Application for a Non-Material Amendment Following a Grant of Planning Permission

Move bedroom window from east to north elevation

North Rear Elevation Proposed

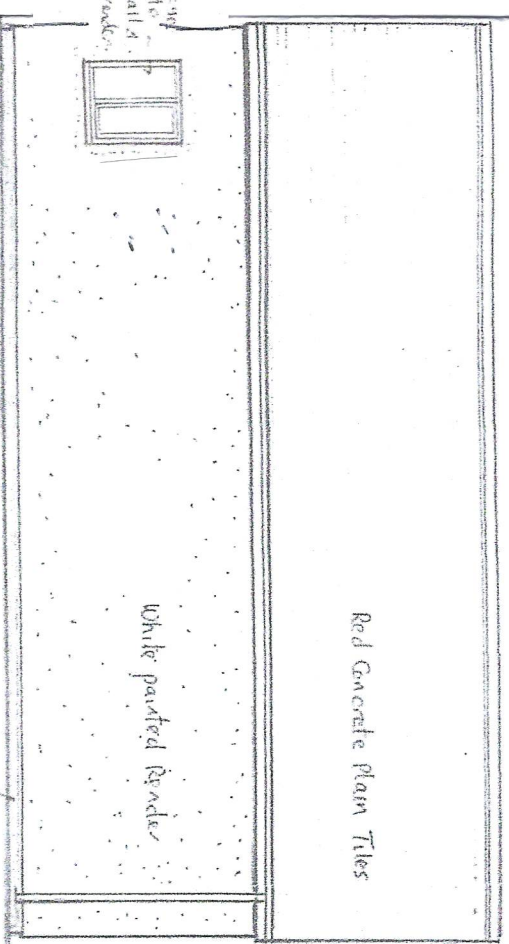
Following the building inspectors visit this morning - the change is required to allow a safe fire escape route
